**KIRKLEES METROPOLITAN COUNCIL  
INVESTMENT & REGENERATION SERVICE**

**DELEGATED DECISION FOR APPLICATION FOR CERTIFICATE OF  
LAWFUL DEVELOPMENT**

Reference no.: 2023/CL/92697/W

Site: Midgebottom House, Sheffield Road, New Mill,  
Holmfirth, HD9 7HA

Proposed Elevations
and Proposed Sections

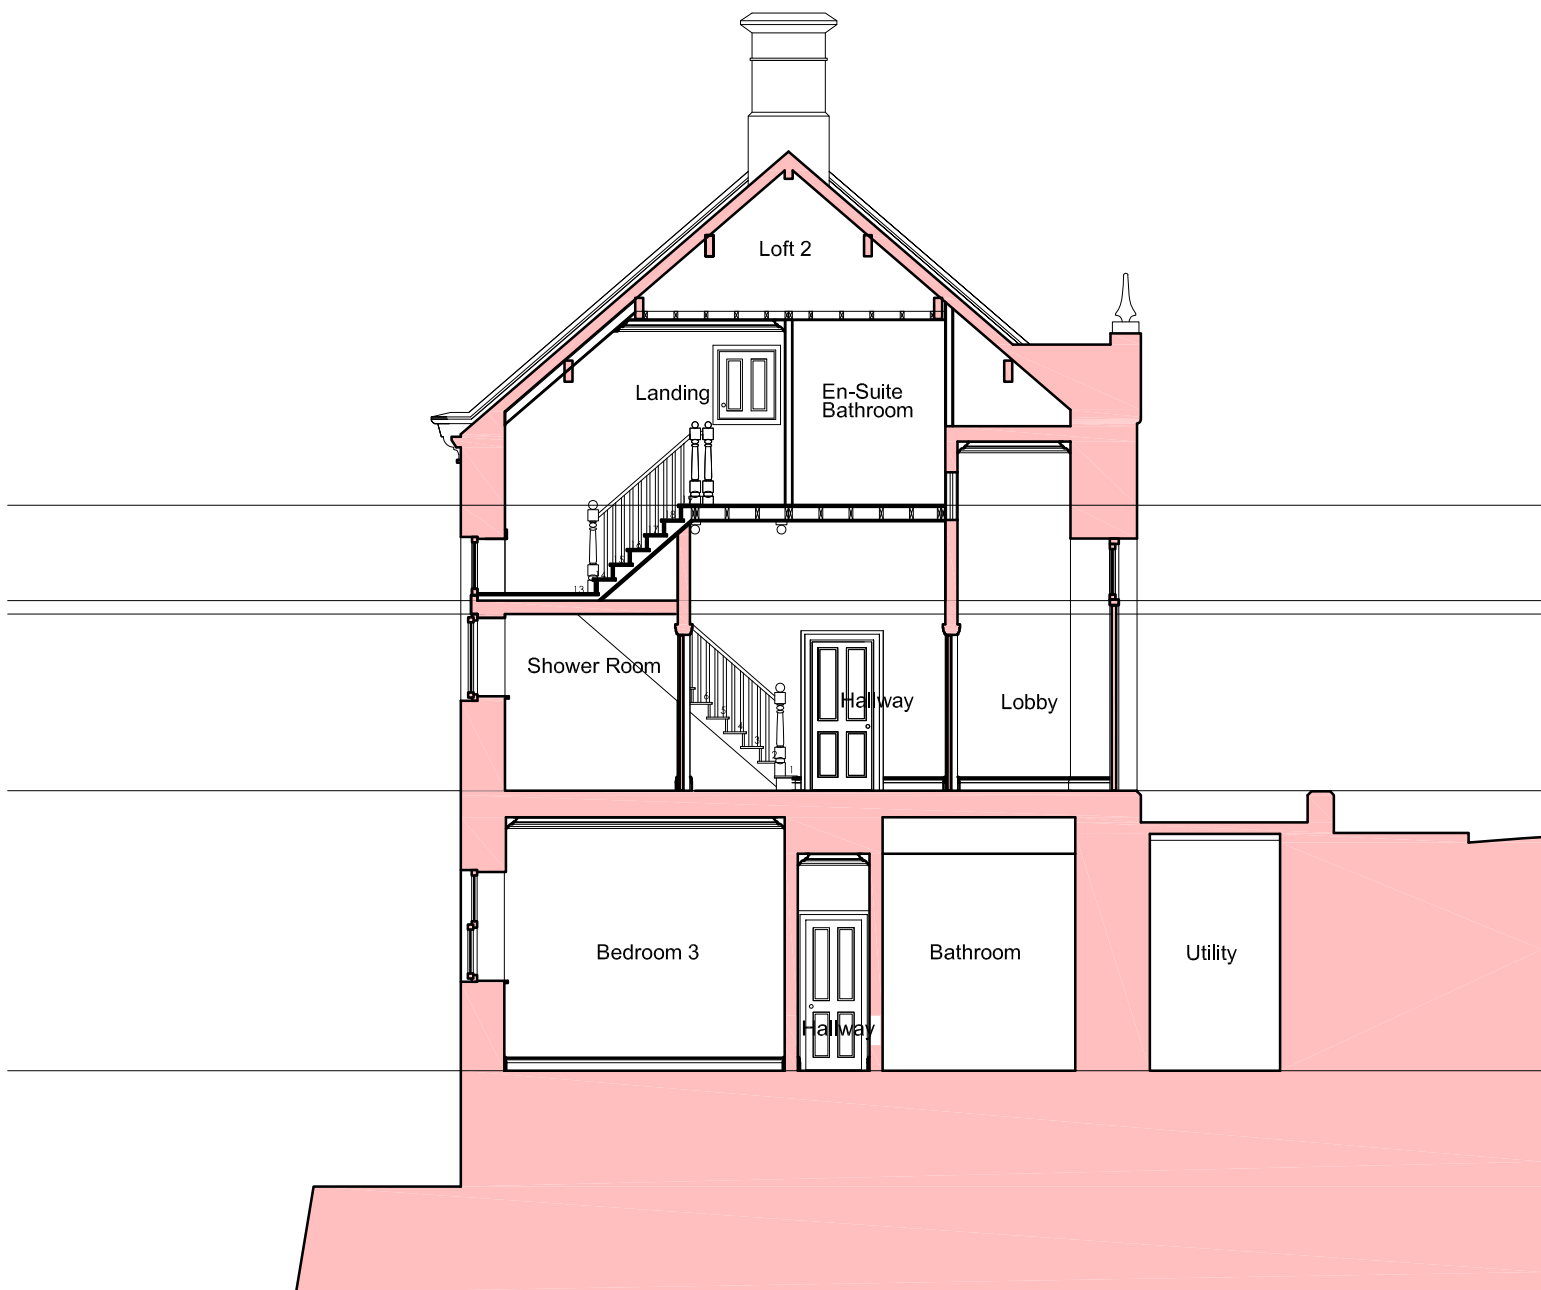
**Comment** *The rooflights would not protrude more than 0.15 meters beyond the plane of the slope of the original roof.*

**Comment** *The highest part of the alteration would not be higher than the highest part of the original roof.*

***Comment:*** *The proposed solar panels would not protrude more than 0.2 metres beyond the plane of the wall or roof slope.*

***Comment:*** *The solar panels proposed would not be above the highest point of the roof of the existing dwelling.*

**Comment:** The building the solar panels are proposed for is located back from the highway and would not impact the amenity of the local area. The solar panels are to be placed only on one roof slope, therefore not dominating the overall roof of the building.
